Fenwick Solar Project Limited

**Planning Act 2008 – Application for a Development Consent Order for Fenwick Solar Farm**

**Applicant Response to Section 51 Advice Letter dated 29 November 2024**

**Application Ref: EN010152**

PLAN TITLE
Waterbodies in a River Basin Management Plan - Sheet 8 of 11

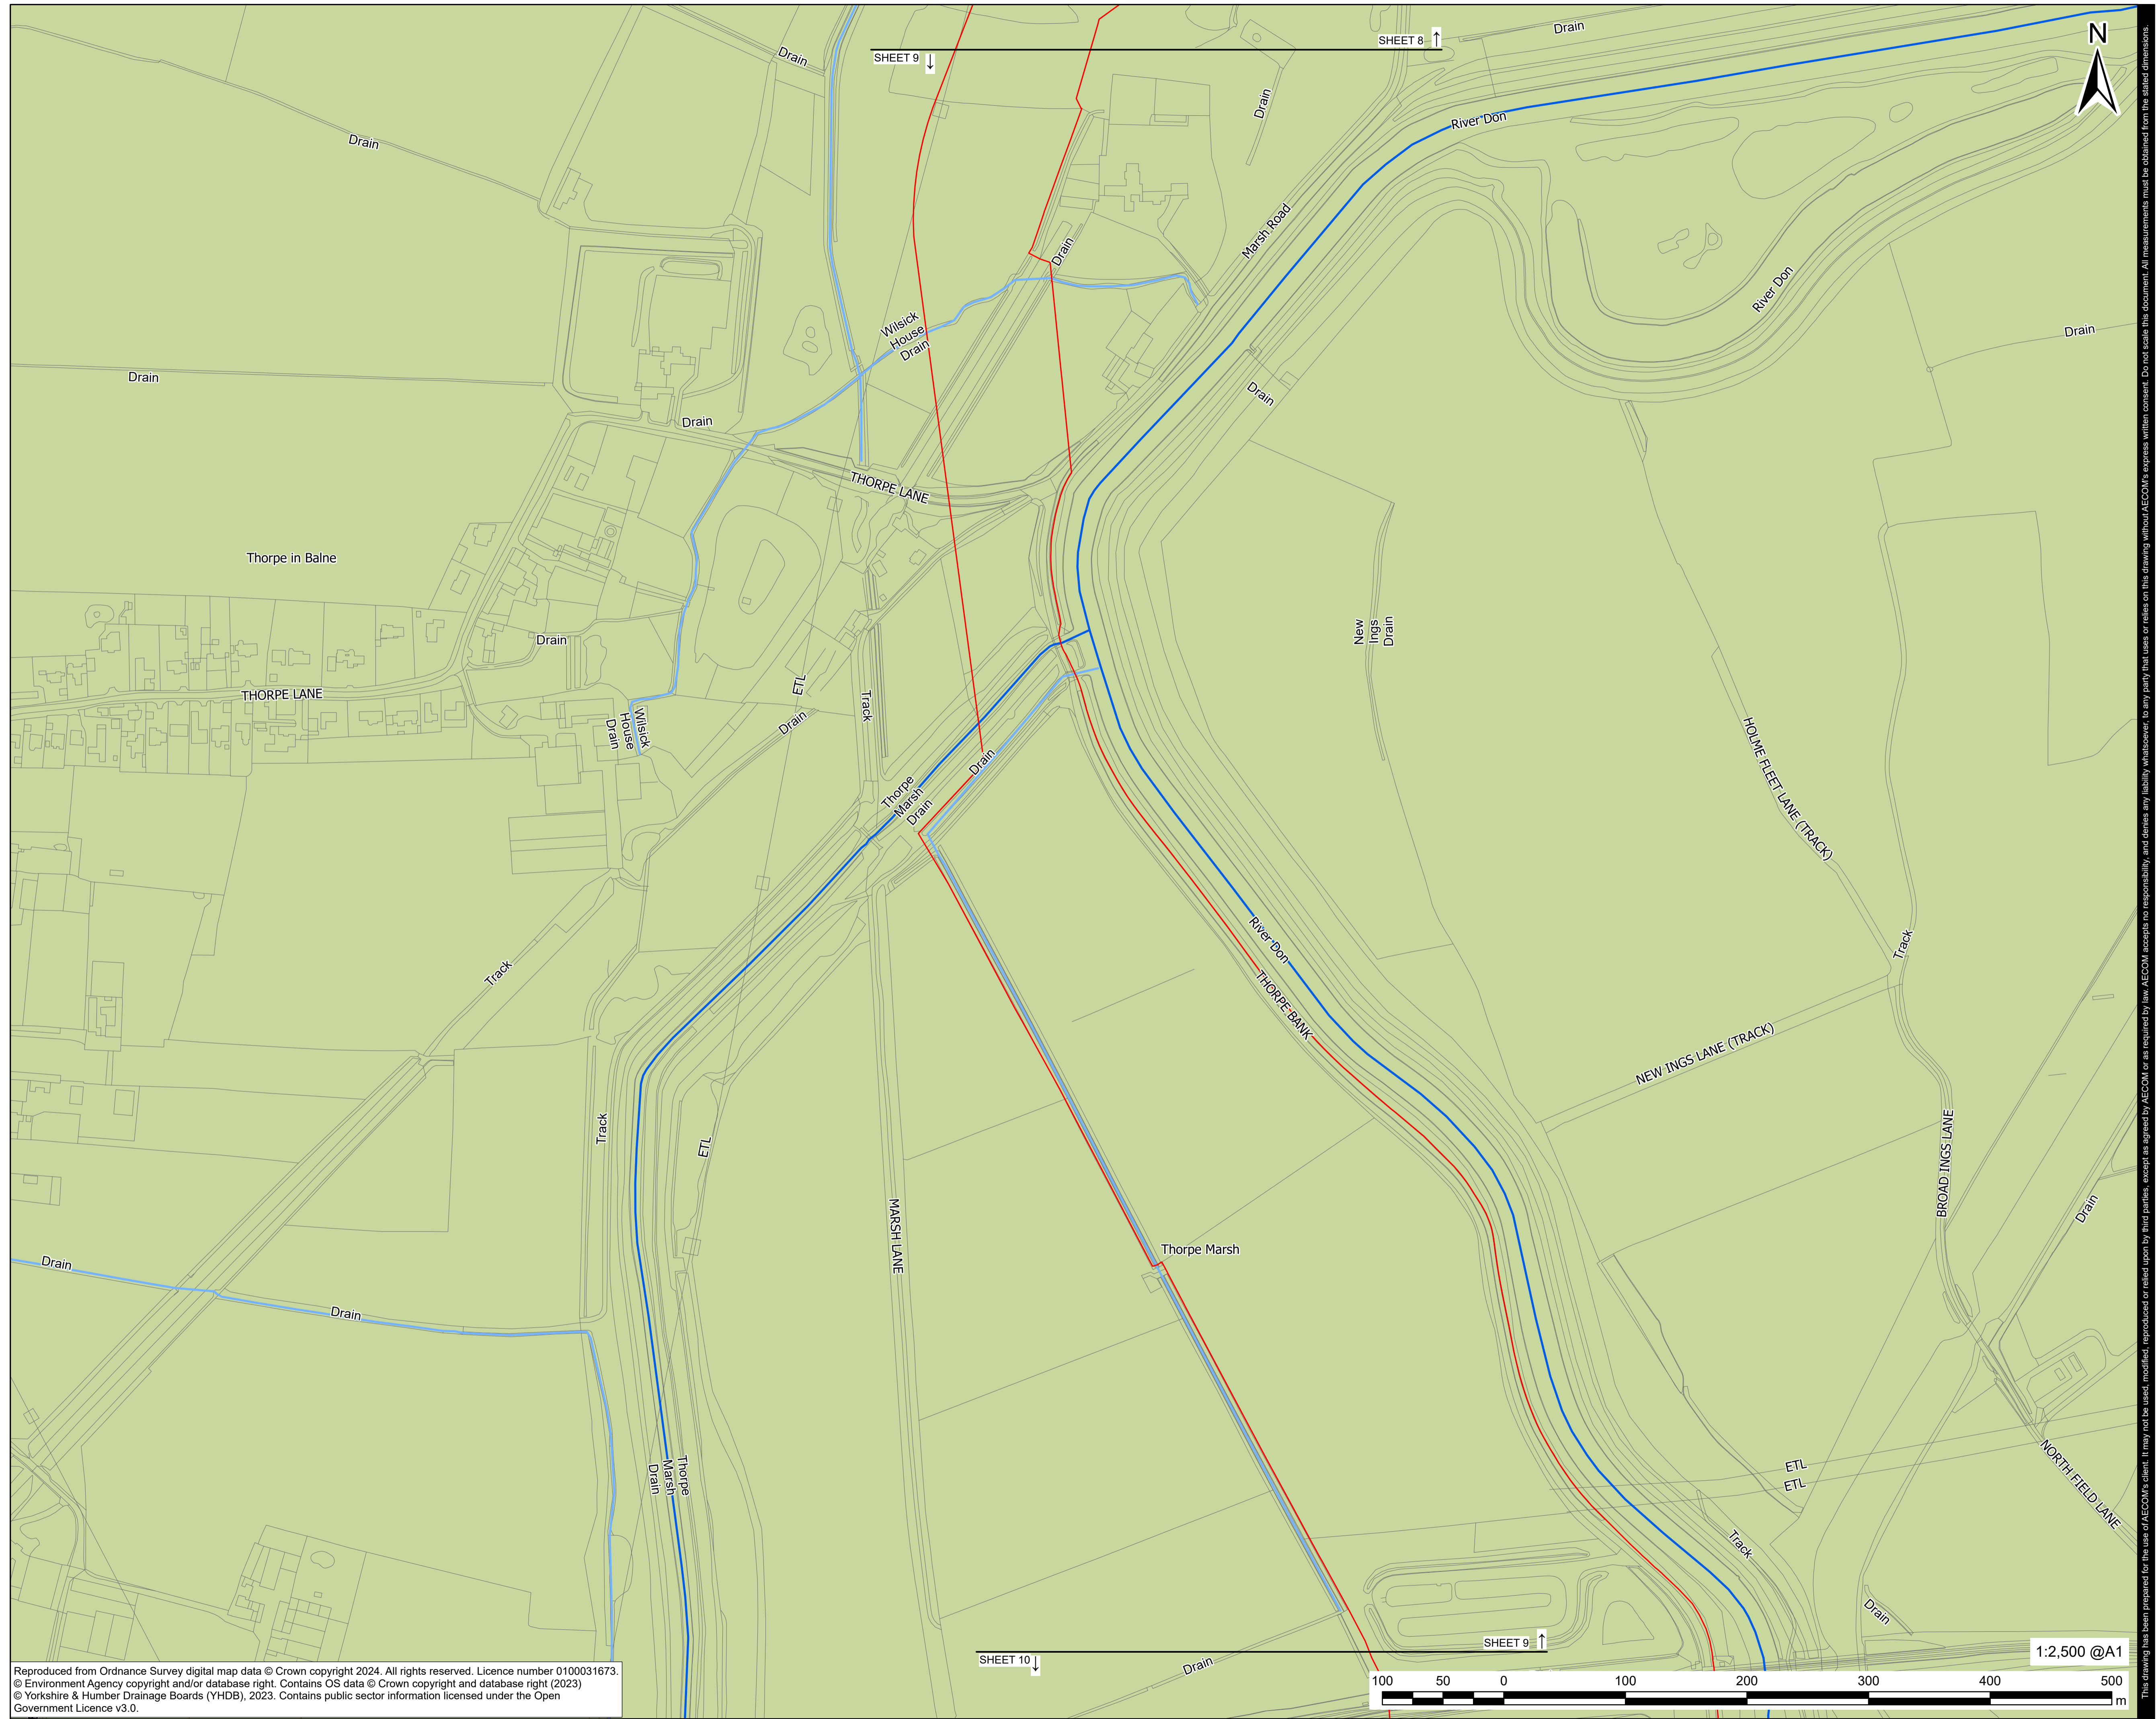
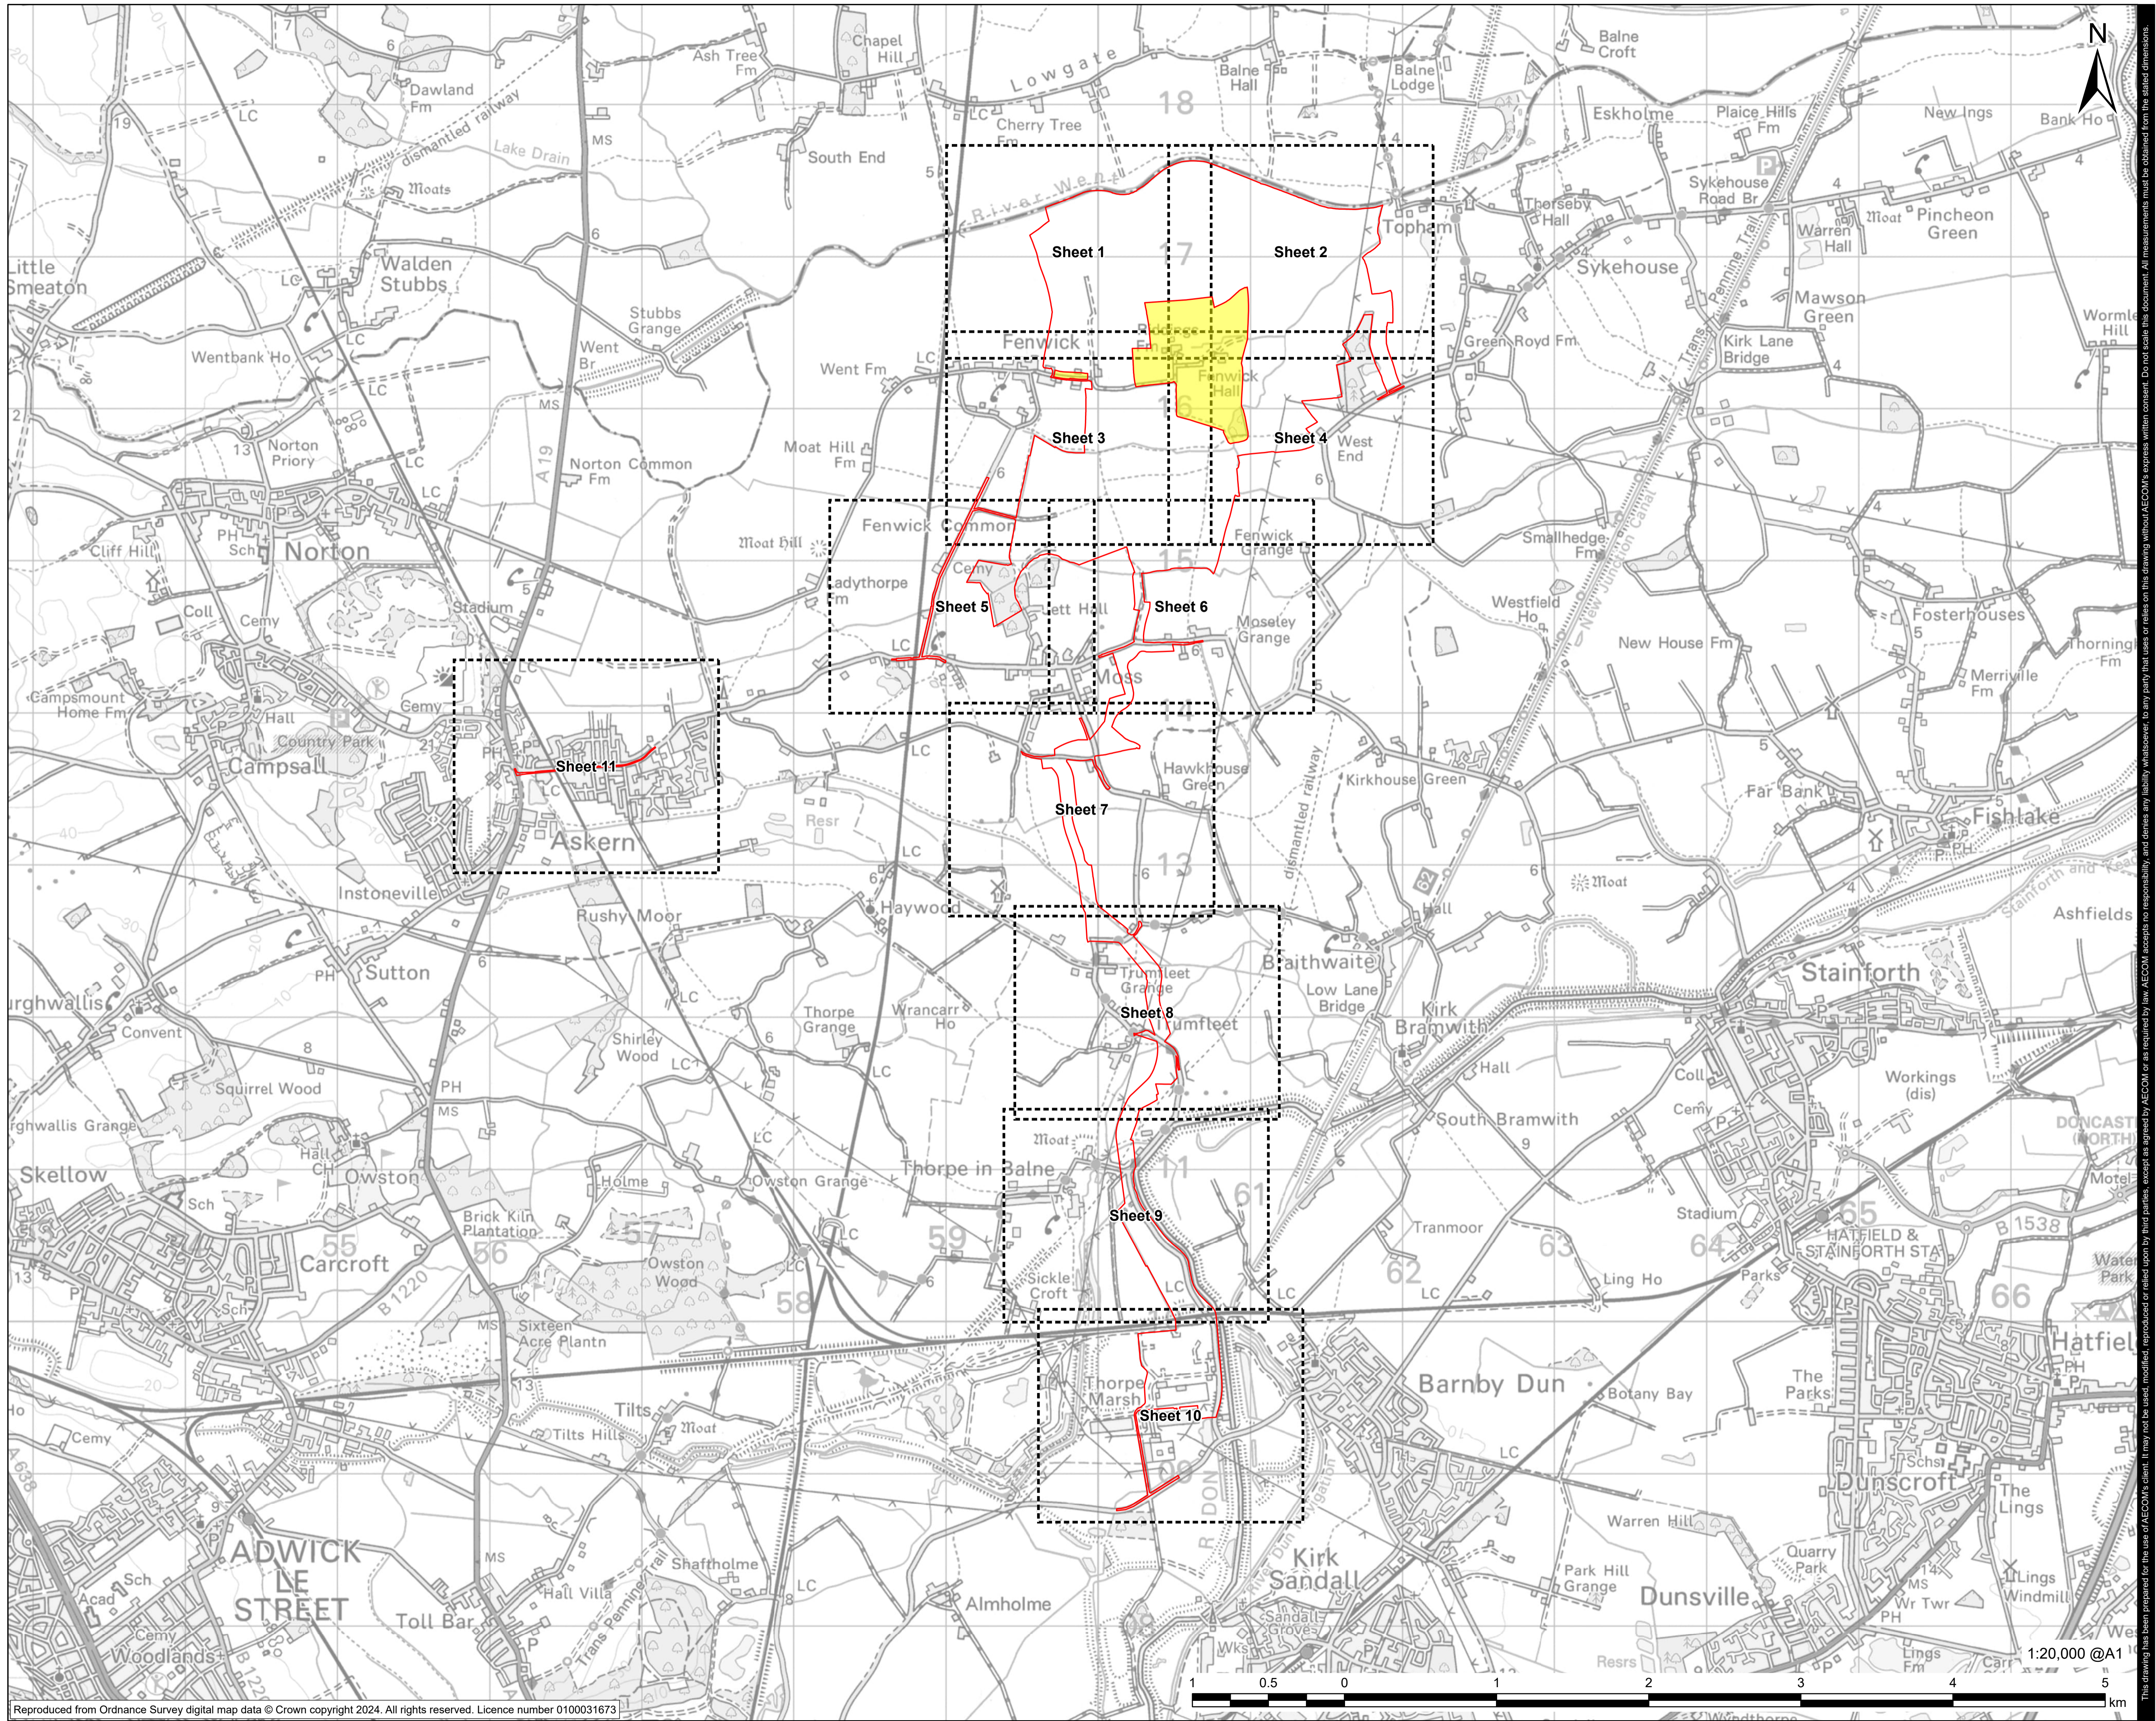
- 1.3.7 The **Waterbodies in River Basin Management Plan [EN010152/APP/2.8]** has been updated by adding missing labels of Ordinary Watercourses that are already identified on ES Fig 9-1 Surface Water Features and Attributes **[EN010152/APP/6.2]**. Also, the updated Plan adopts a lighter blue for Ordinary Watercourses, a darker blue for Main River and the colour of the Aire & Don Sherwood Sandstone layer has been changed from green to orange (noting that orange and blue provides a more accessible palette combination).
